Your Ref: OWPC18273
Our Ref: AB/33/18/HH 26-03-2018
Please ask for:
Zac Denton

Extension of garage, replacement of conservatory, reordering & associated works
6 Birch Close Arundel

Thank you for your internet representation made on 16th May 2018 which has been recorded as '**an objection**' with the comments as follows:

Site/Block Plan
As Proposed

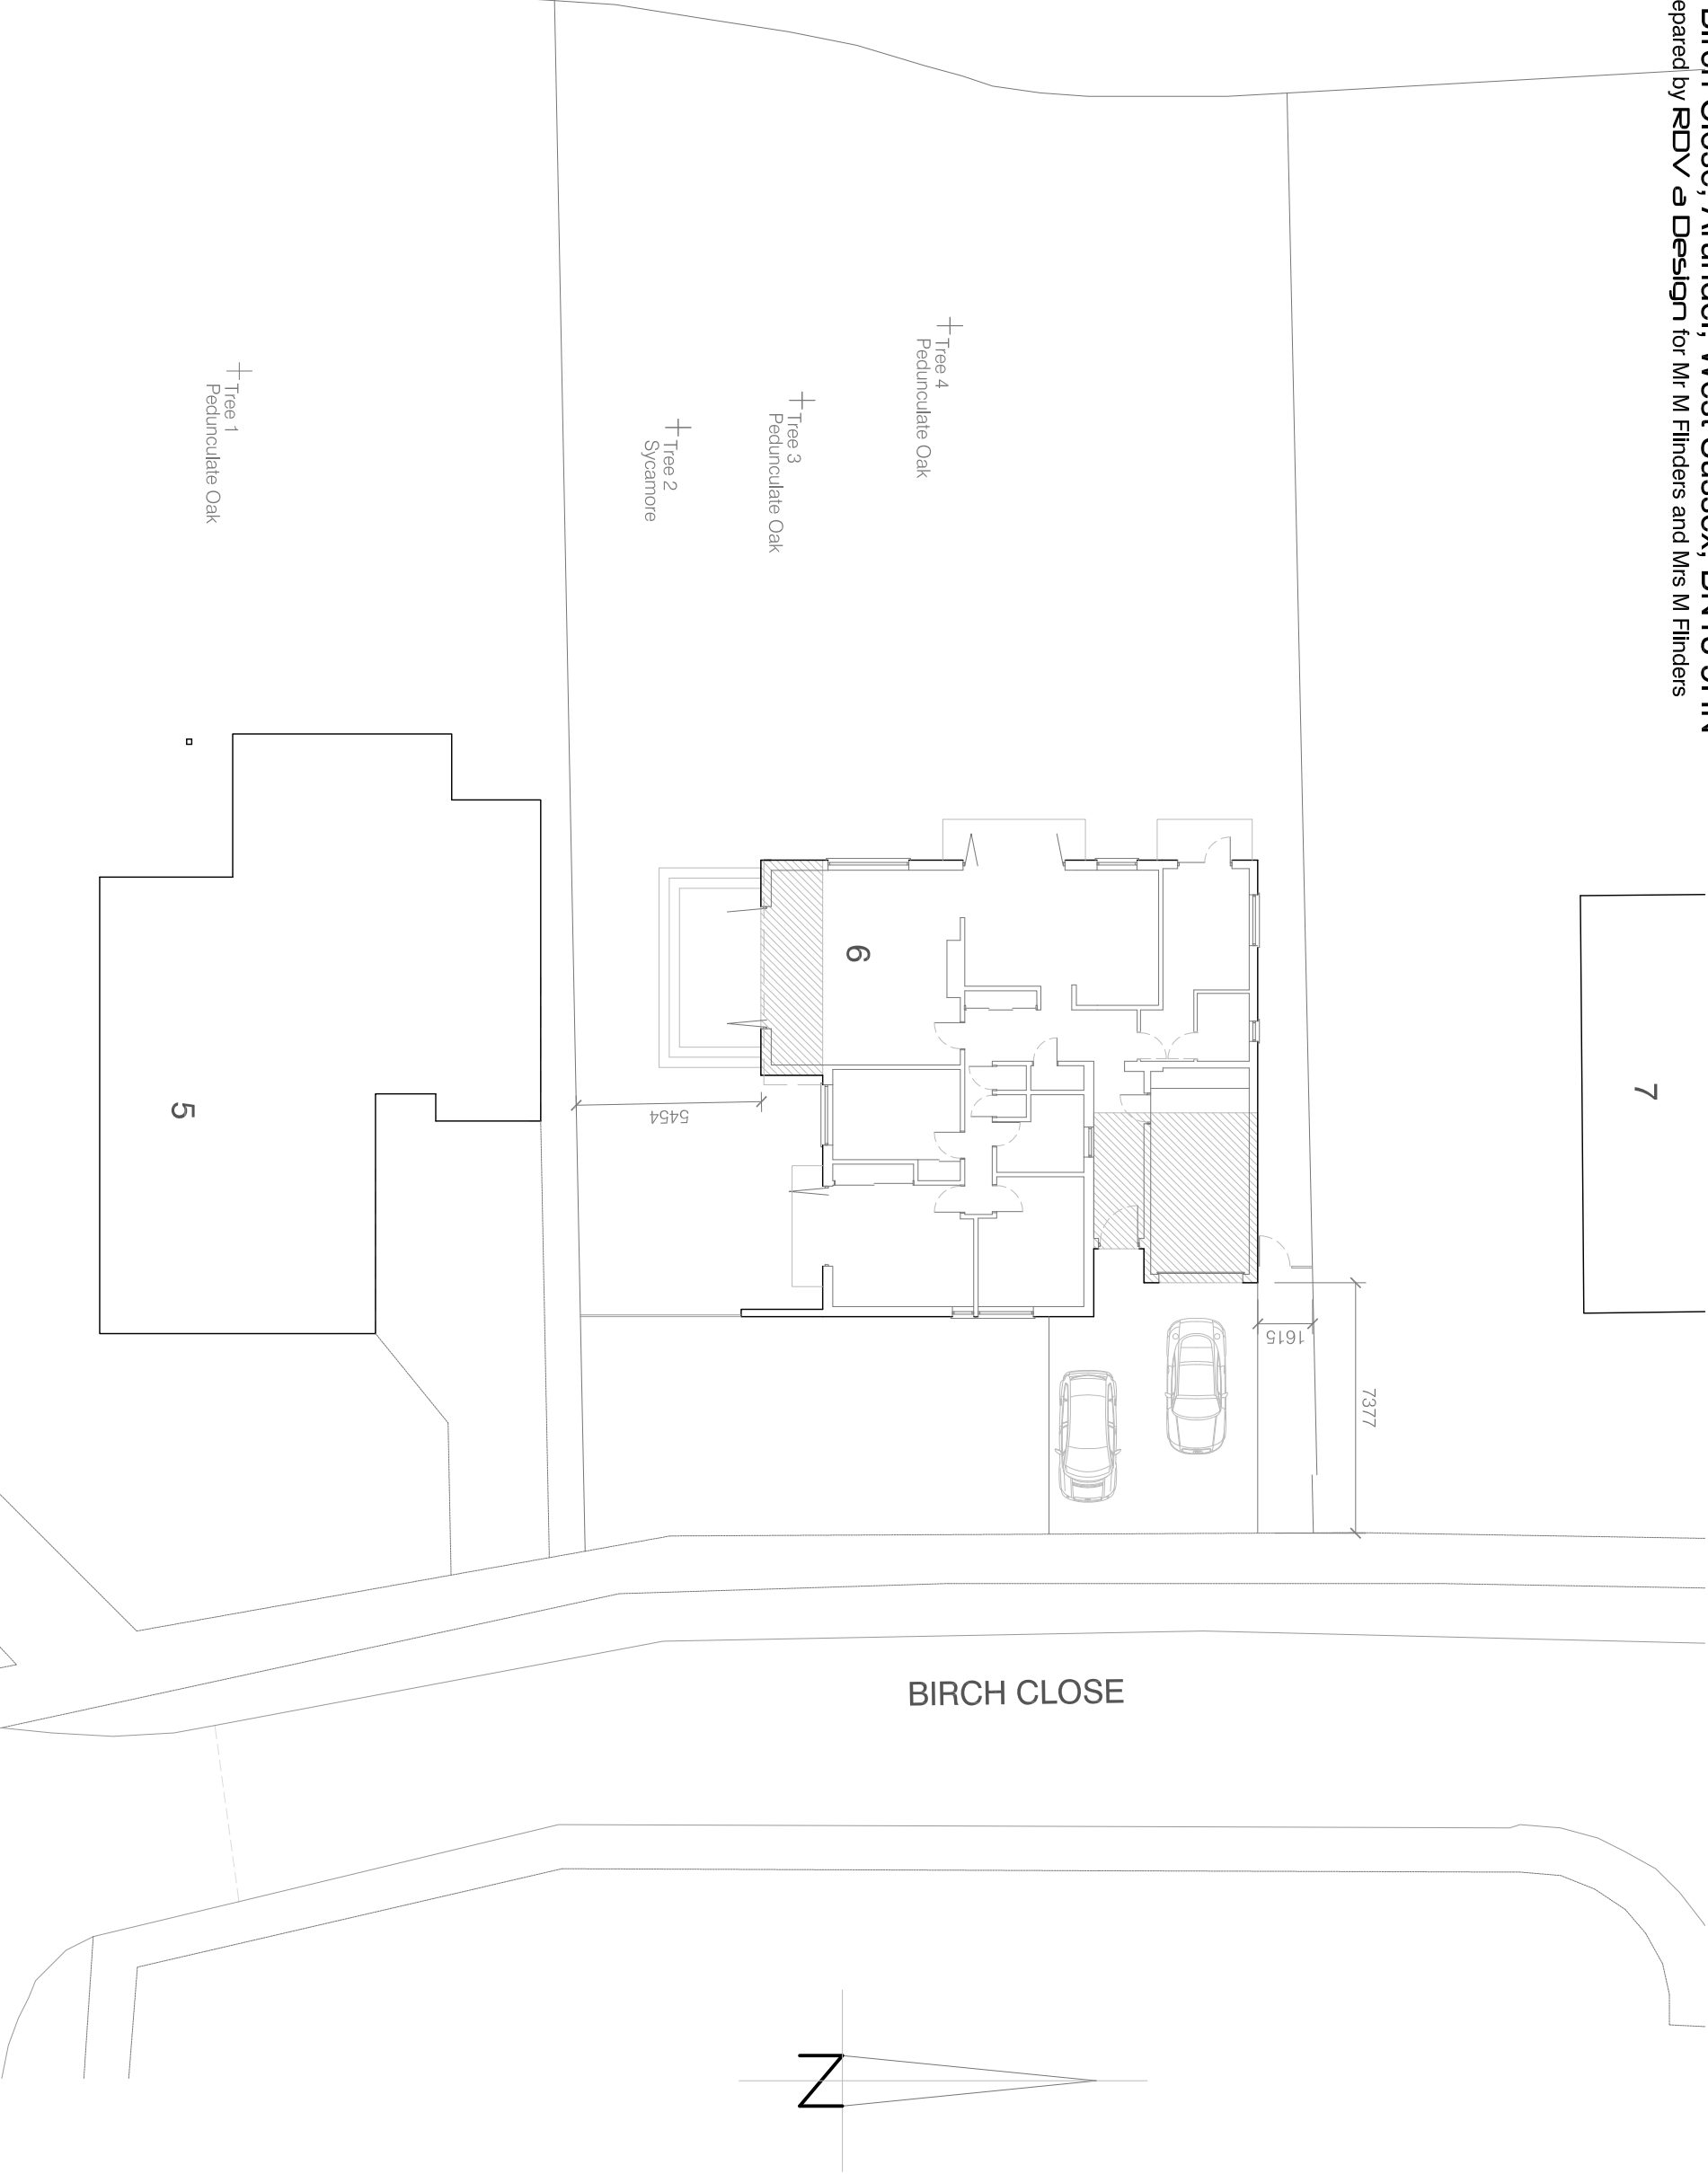
Our 2nd concern is that to build a garage almost to the front line of the property would change the appearance of the road as all the properties in Birch Close have identical set back garages.

All other extensions which have been added to properties in Birch Close have been built in the large rear gardens so as not to change the appearance of Birch Close and we believe that the proposed development would therefore be out of keeping with the character and appearance of the road and give rise to unacceptable detriment to visual amenity in conflict with policy GEN7 of the Arun District Local Plan, 2003 and policies D DM1, D DM4 and D SP1 in the Emerging Arun Local Plan 2011-2031 (Publication Version, October 2014)

Ground Floor Plan: Scale 1:100

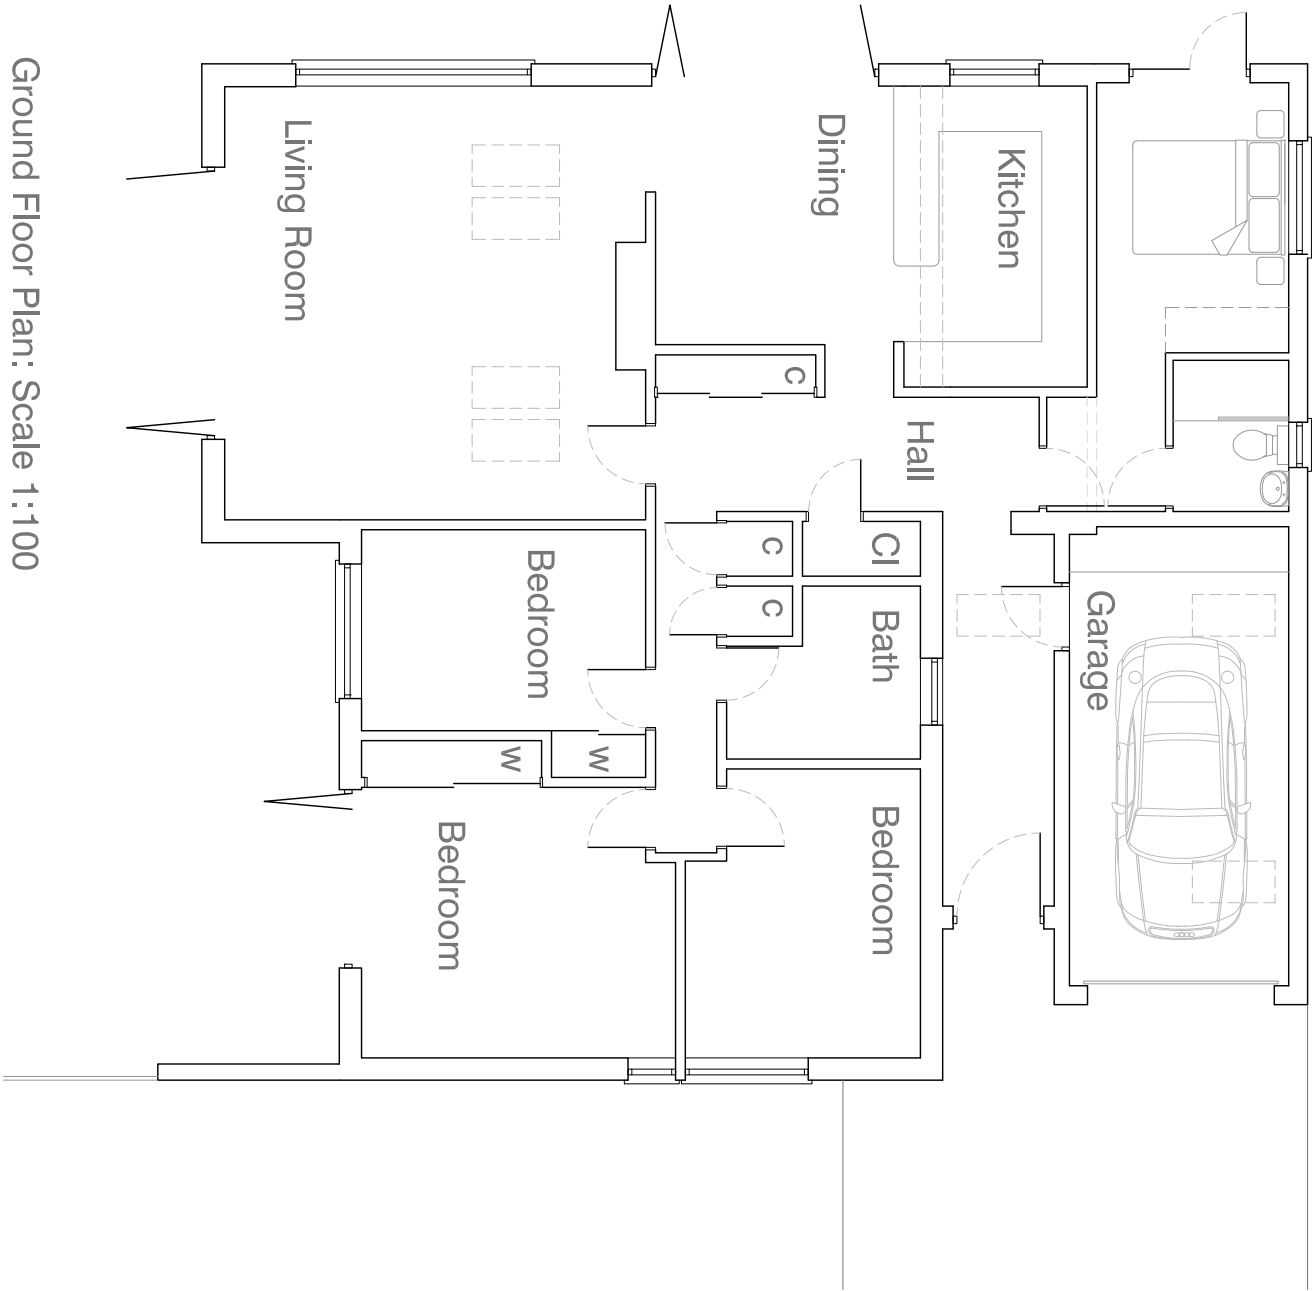
The plans show that the residents of 6 Birch close wish to turn the existing garage into a double bedroom and then build a new garage to the front of the property. Our concerns are that a double bedroom could conceivably be filled with another 2 adults with another 2 cars and then parking and manoeuvrability would become difficult for all concerned as the road is not only short but narrow as well.
